Jeanie Bourke - Re: fire safety discussions - 39 Cumberland

From: Jeanie Bourke
To: Gil Helmick; John Martell
Date: 3/14/2014 1:16 PM
Subject: Re: fire safety discussions - 39 Cumberland
Attachments: 39 Cumberland inspection results.pdf; cumberland 39 inspections.pdf

A1 1/4"=1'-0" BASEMENT PLAN

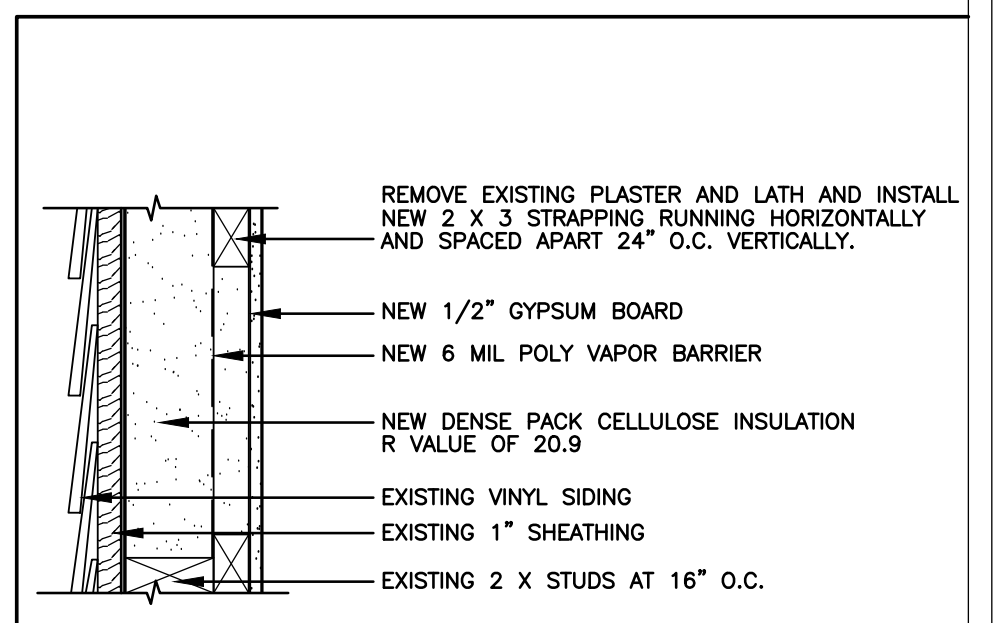
As a first point of order, I spoke with Brian about the electrical panels in relation to the proposed wall location. The existing panels, while not compliant, are allowed to remain. No new work shall make this situation less compliant, this wall will do that. If you need clarification on this have your electrician contact Brian. Is there another window that can be utilized for emergency escape and rescue?

Secondly, John and I discussed your proposal to extend the "sound studio" space to include a vocal room. Per our previous meeting this week, the agreement was for a compliance alternative in the multifamily residential basement area, therefore, the proposed expansion of habitable space cannot be allowed. The use of this basement has exceeded the intent that you presented in the original permit application. Of primary concern is the addition of an emergency escape and rescue window.

1. separate boiler room with fire wall and door. [60 - 90 minute rated door] **60 minute minimum**
2. close the open ends of the existing fire rated ceiling **yes, with drywall**
3. convert mechanical room window to emergency exit **not approved**
4. create passage from sound studio to emergency exit **yes, to approved location**
5. add fire / carbon monoxide alarm outside br 1 / hall **yes**
6. add fire / carbon monoxide alarm fl 2 hall apt c, **yes**
7. add fire / carbon monoxide alarm to sound studio **just smoke ok**
8. add fire / carbon monoxide alarm to cellar entry area **yes**
